MARYSVILLE
COMMUNITY
DEVELOPMENT

August 1, 2022

Re: 22-Unit Townhome – 11115 Smokey Point Blvd Avenue (PA 22-027 Mack Townhomes)

TEC HOLDINGS 123, LLC
MACK TOWNHOMES
 PRELIMINARY SITE PLAN

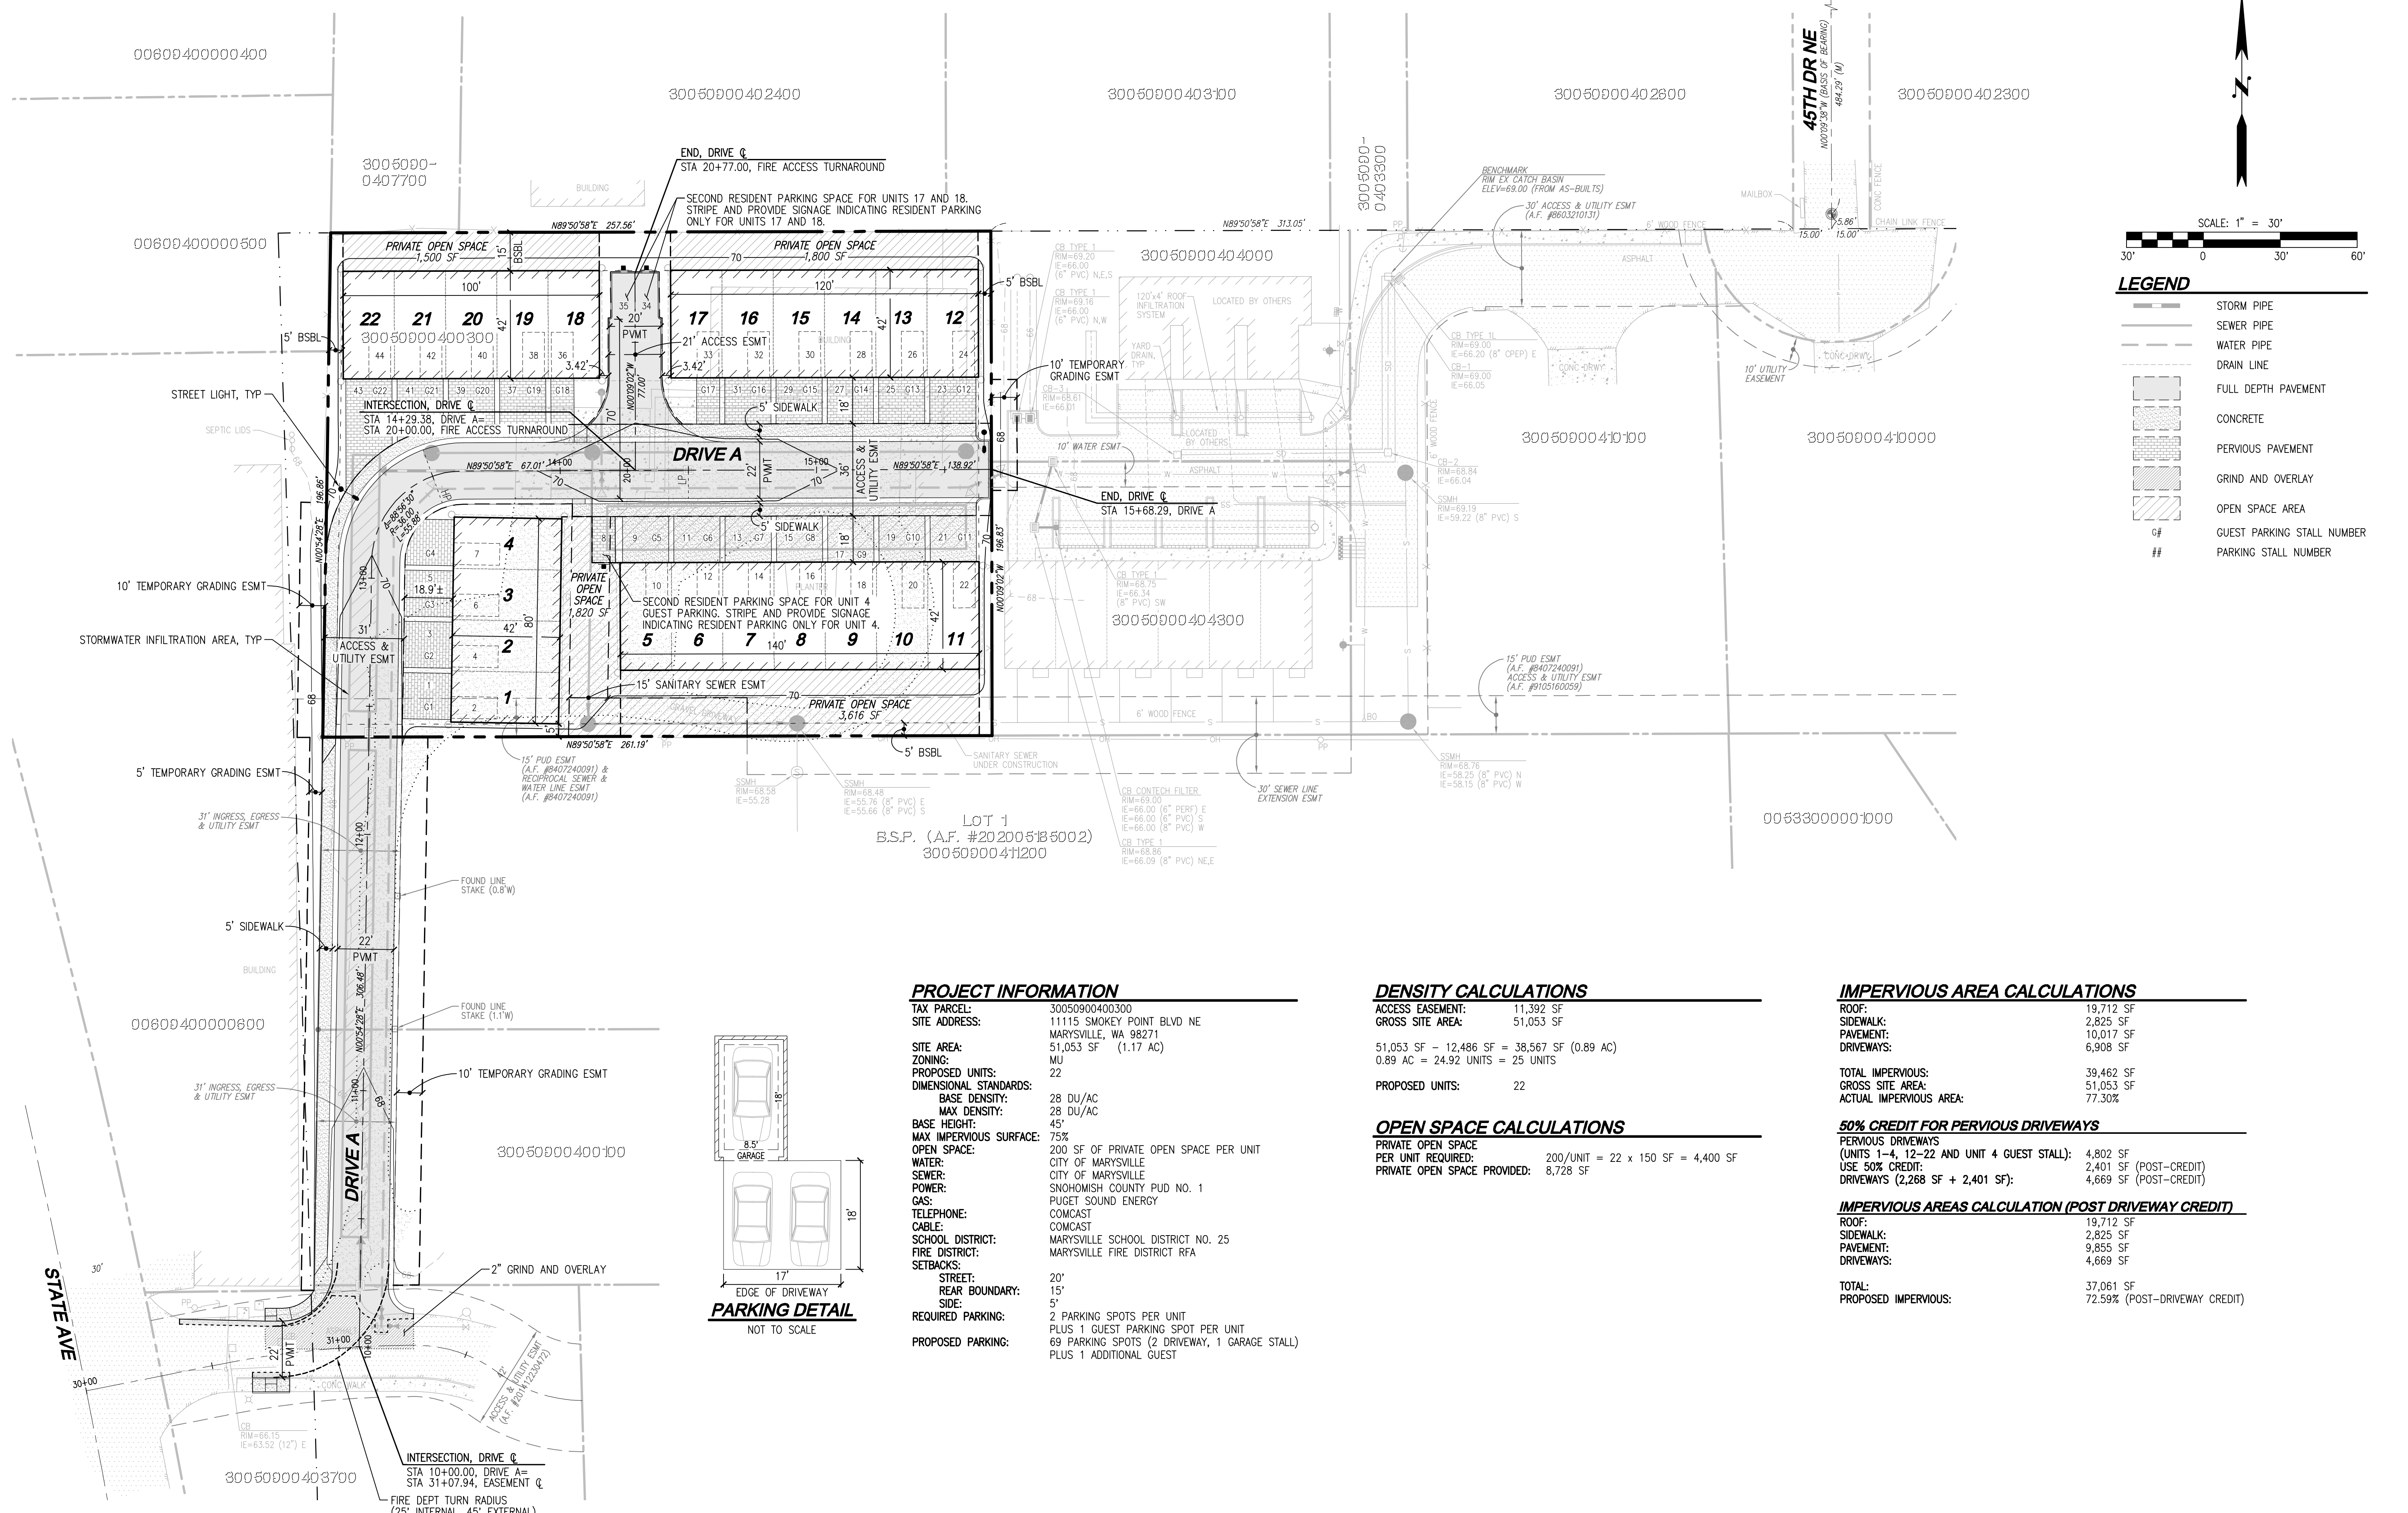
- 1) The Pedestrian pathway connections to the development to the east do not connect to the walkways of the development currently under construction. Please see redline site plan attached for suggested revisions to ensure connection of ped. paths between developments.

- 2) Please identify the AFN for the access easement on parcel 3005000041120.
- 3) Please include AFN's for all easements and encumbrances and depict on the site plan/map.

TEC HOLDINGS 123, LLC  
**MACK TOWNHOMES**  
PRELIMINARY ROAD, STORM DRAINAGE AND GRADING PLAN

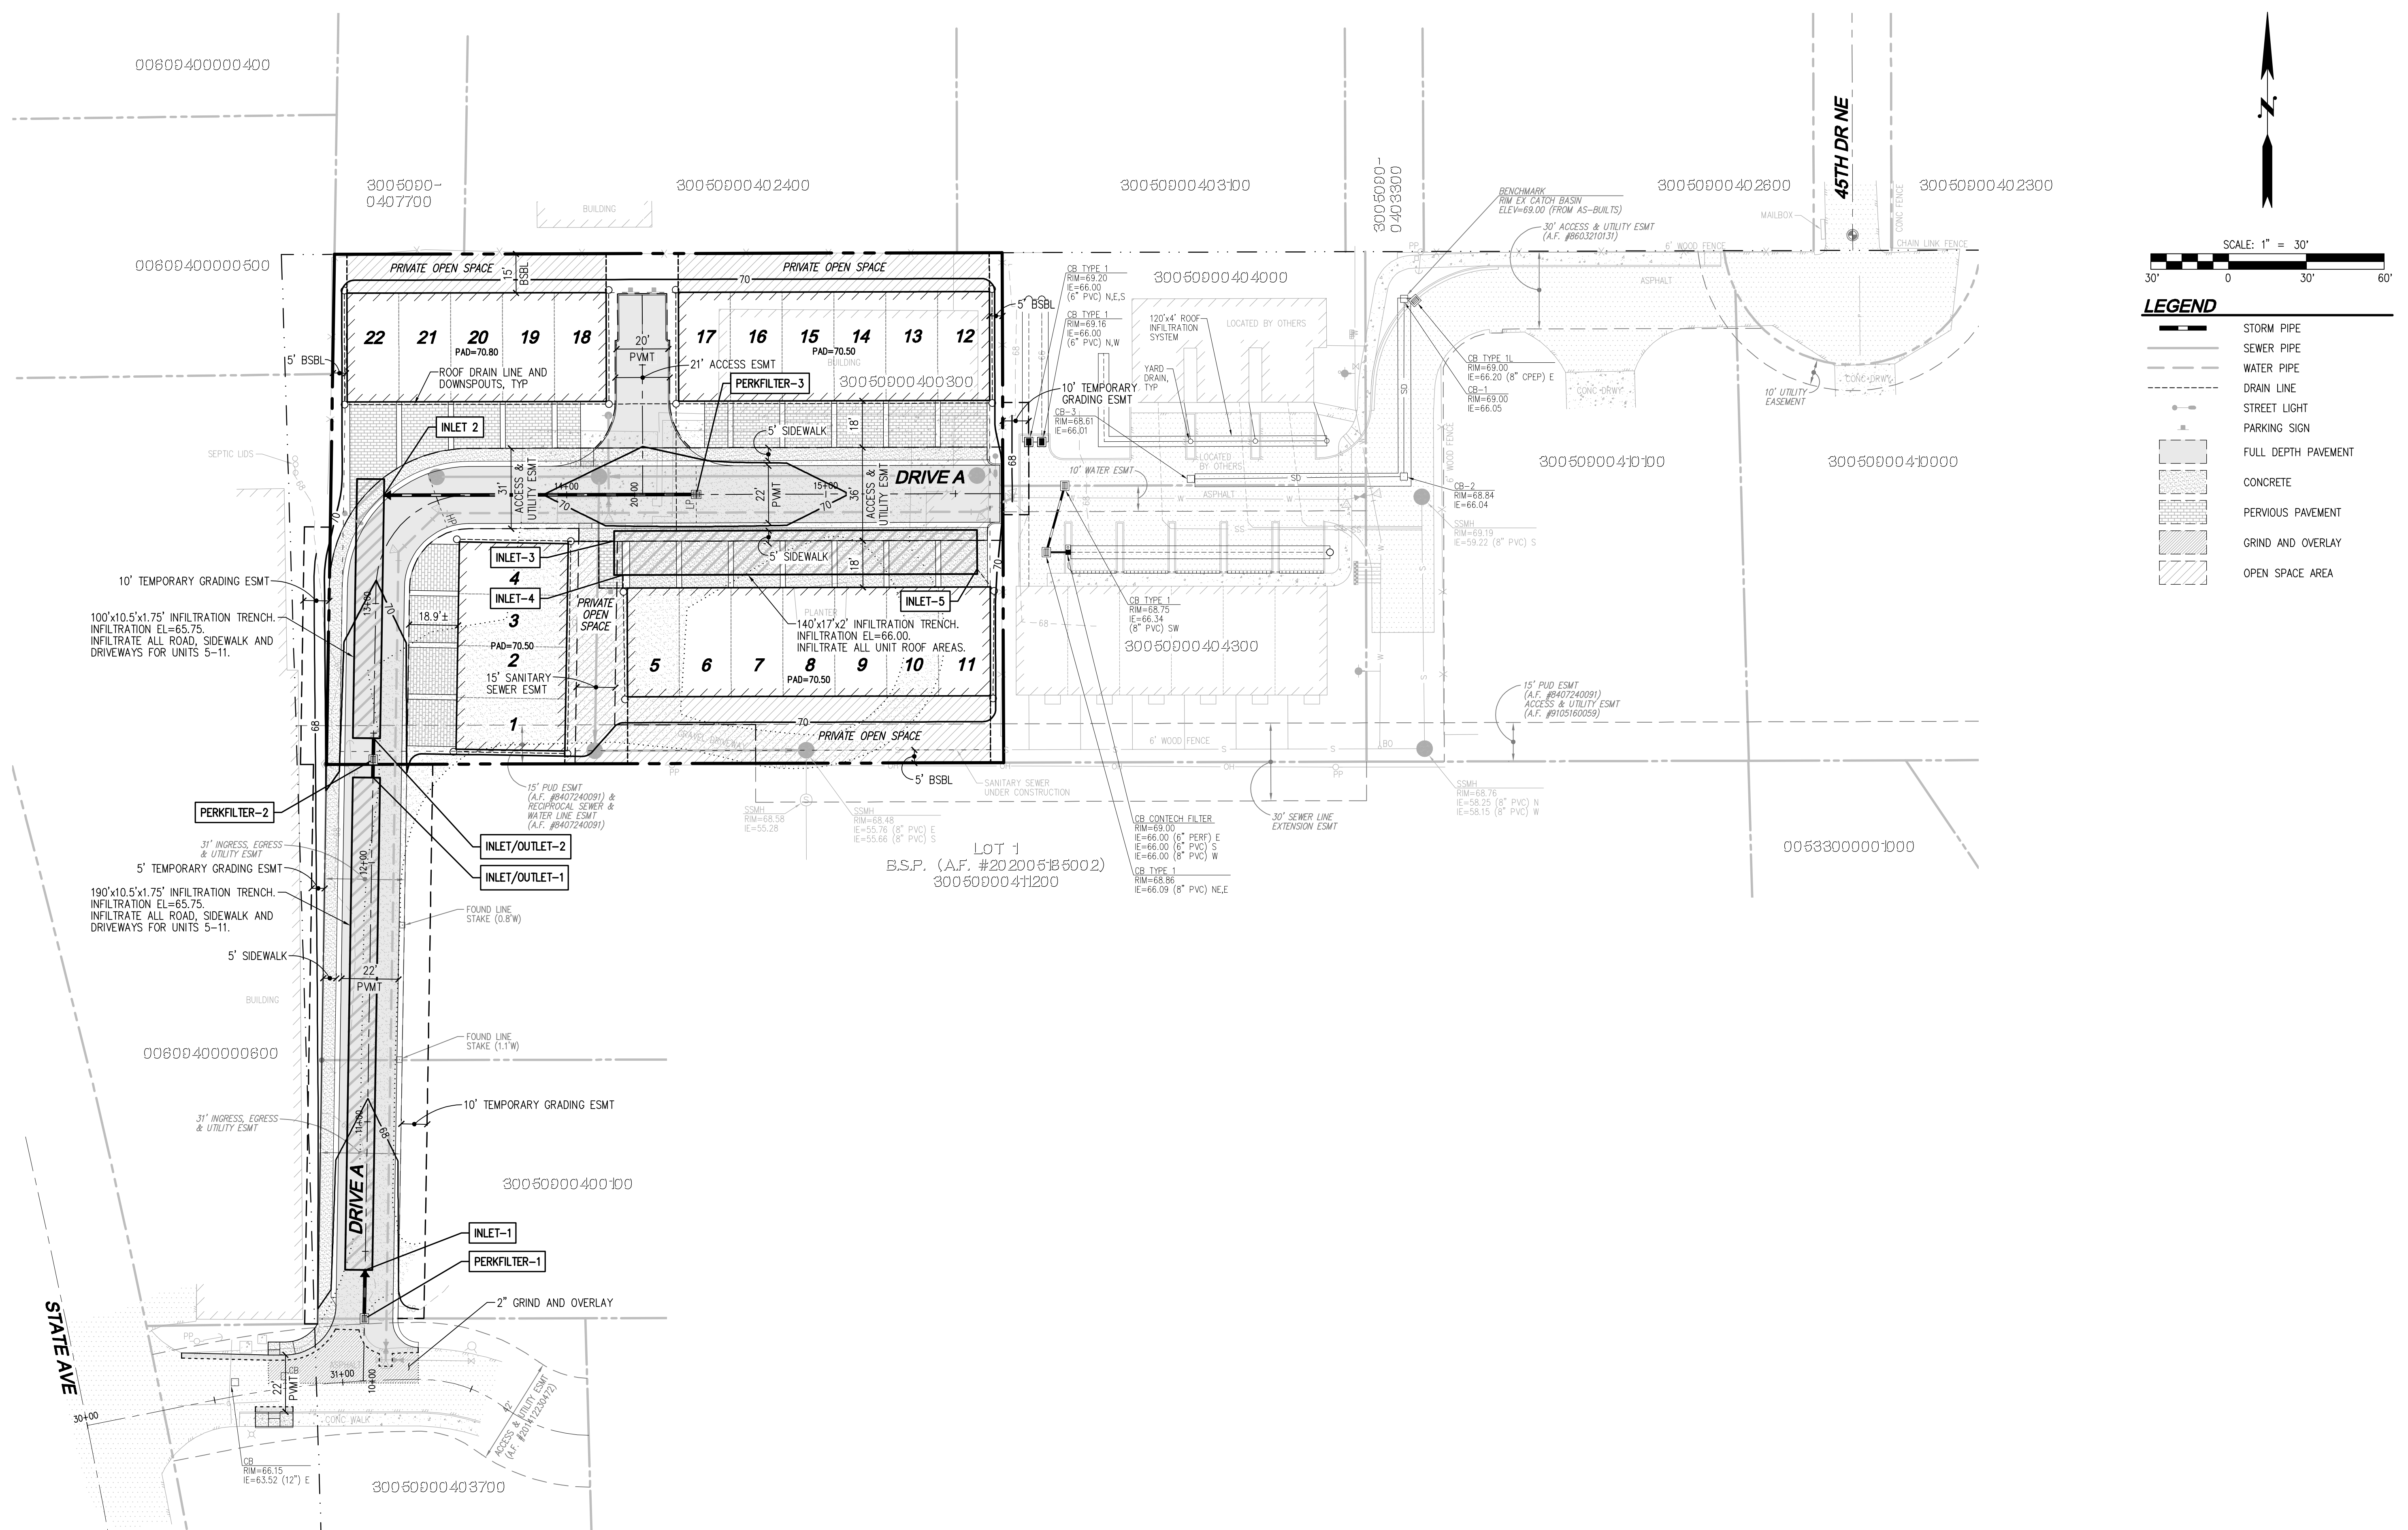
- b. As the project is constructing a private drive, an emergency vehicle turnaround can be allowed versus a cul-de-sac. See standard plan 3-207-004 of the EDDS for the hammerhead design which will need to be constructed on the east end of the project. The design that is shown does not meet the standard.

- b. It appears that the infiltration facilities will only have 3 feet of separation from the seasonal watertable. I did not see a supporting mounding analysis in the submittal to allow for this separation. Please include it in the civil submittal.
